*County of Bernalillo*  
*State of New Mexico*  
*Public Works Division*  
*Transportation Planning Section*  
*415 Silver Ave SW Albuquerque, NM 87102*

Subject: Maxeon Solar in Mesa Del Sol – Draft Traffic Study

Below are Bernalillo County comments on the subject draft TIS dated January 19, 2024, please address these comments for the final submittal.

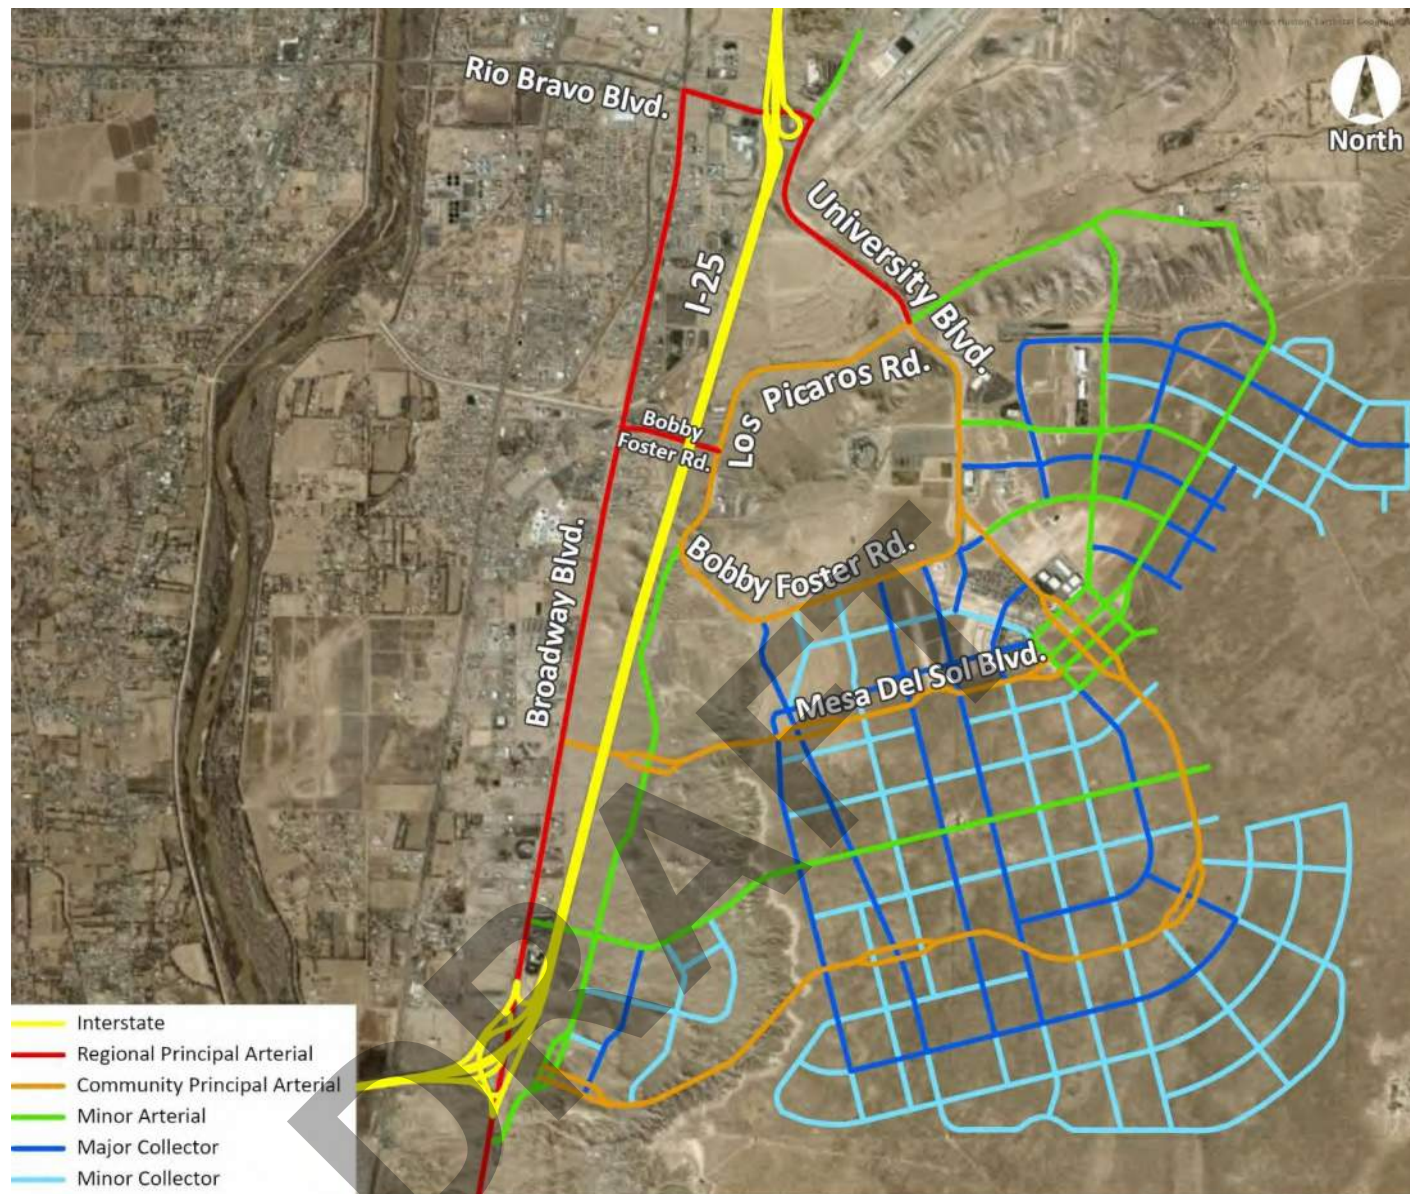
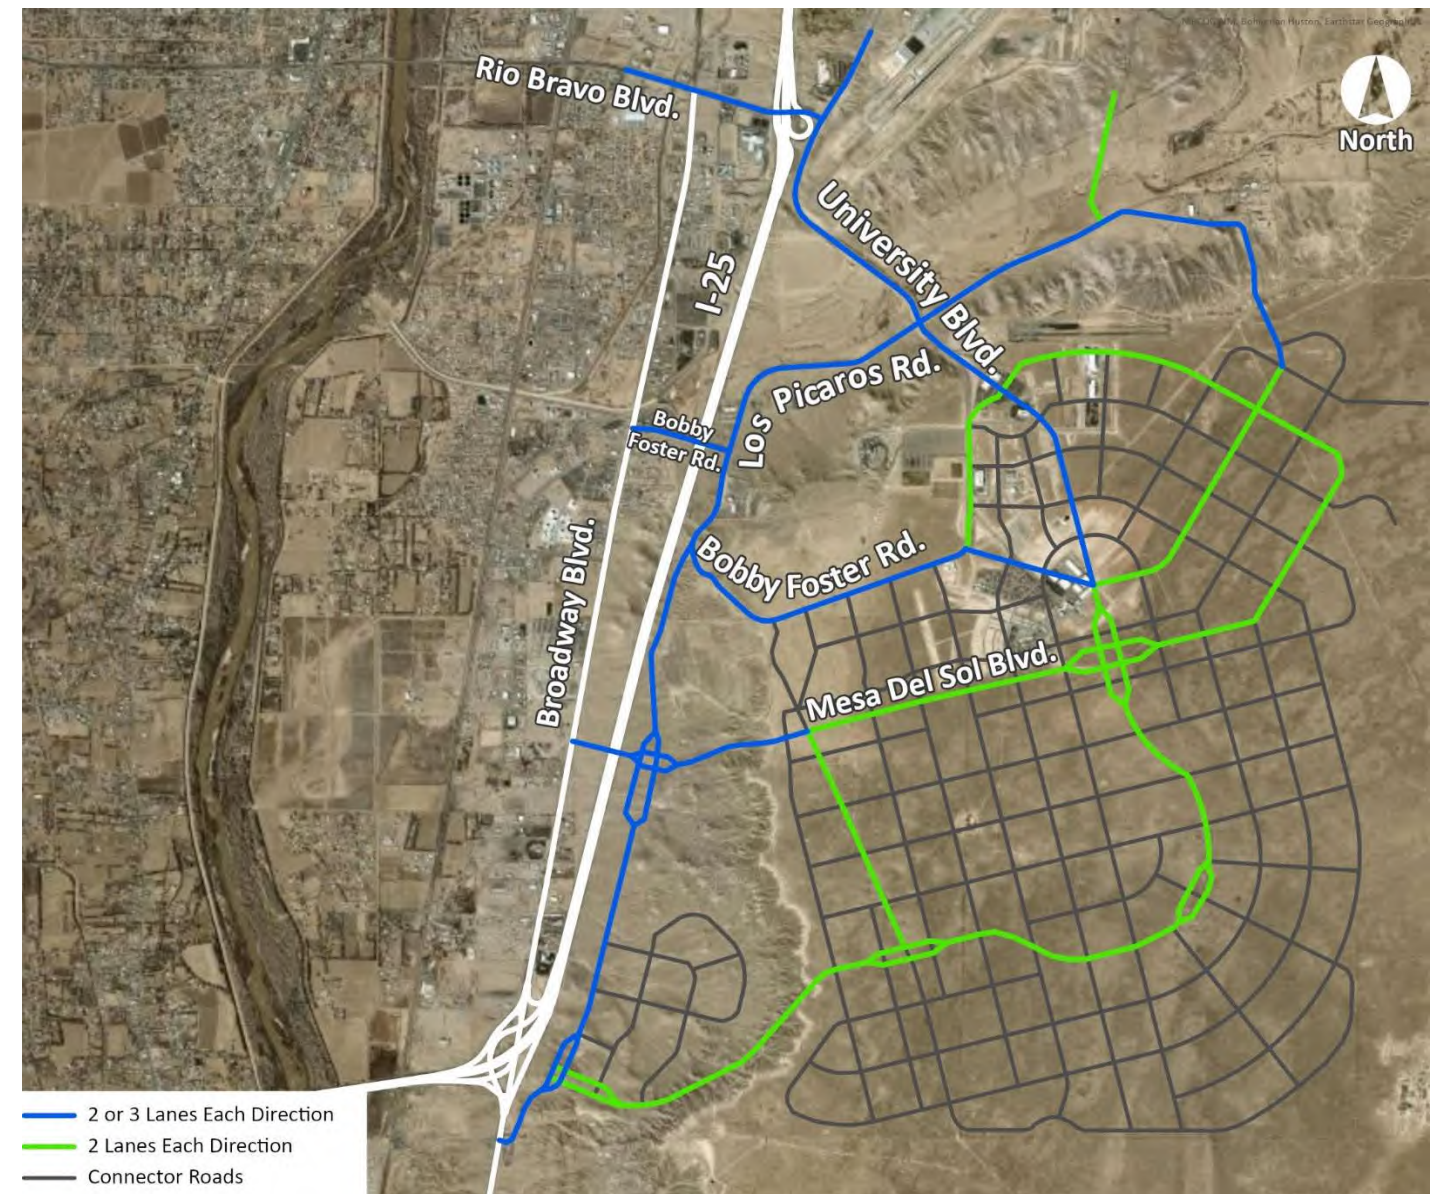
- Provide a road to the site within publicly dedicated ROW that meets COA's DPM standards and allows for future development to use this road.
  - Provide this alignment in all exhibits. Page 2 describes the site at being on "the east side of University Blvd and south of a proposed east/west industrial collector roadway to be identified as Maxeon Way." This needs to be shown on Figure 4 (page 8).

7. **Page 8 Figure 4** – Show the location of the Maxeon site on these two map images along with the proposed temporary road path. Maxeon should contribute to the planned roadway network and it is important to show how the location relates to the planned network.

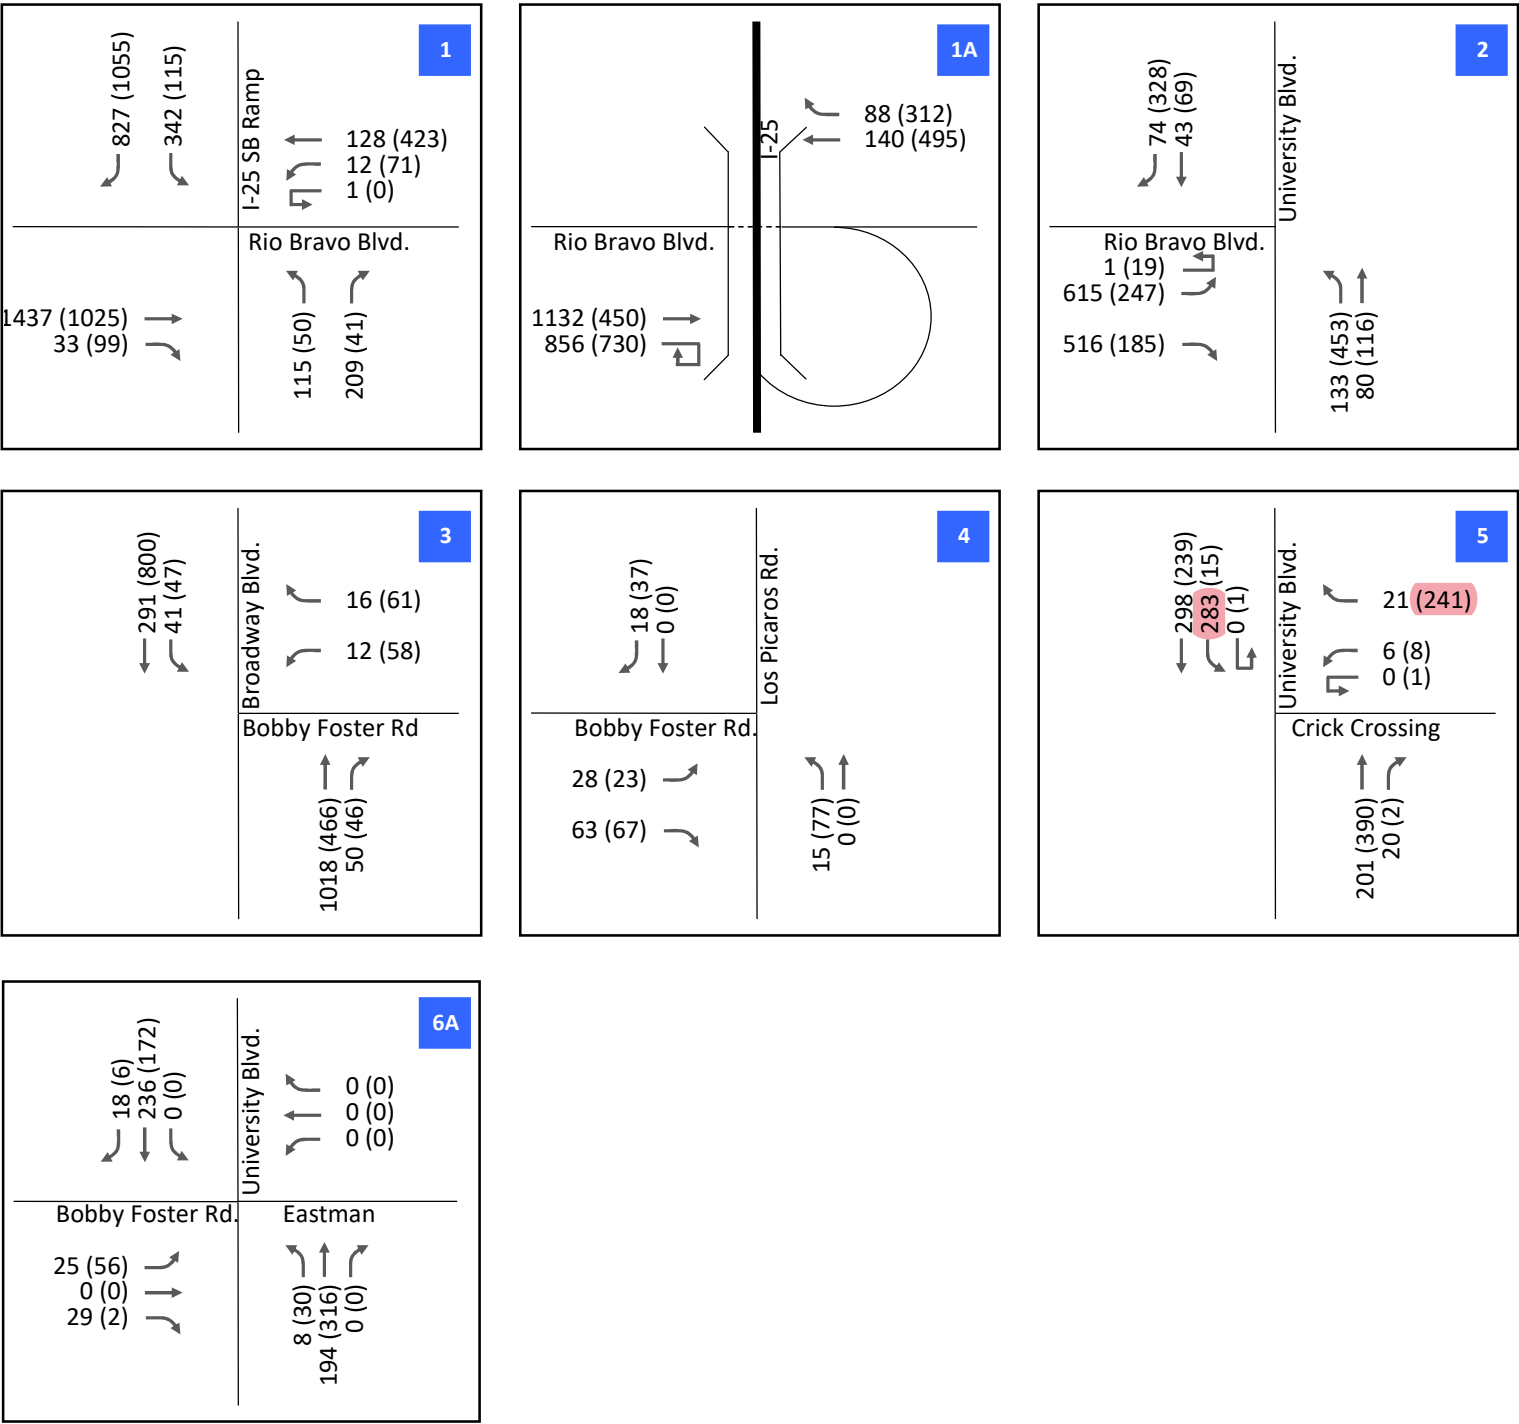
8. **Page 23 Ambient Growth** – The growth rate of 4% is extremely high. There is a significant amount of growth captured by previously listed developments. On page 7 under the description of University Blvd, there is nearly constant growth from 2017 to 2022. Basing this rate alone on the MRCOG model is incomplete. The model takes into account planned projects such as the ones listed on this page. By including both 4% general growth and the planned project growth, the trips are being double counted and providing an overestimate of the horizon year scenario.
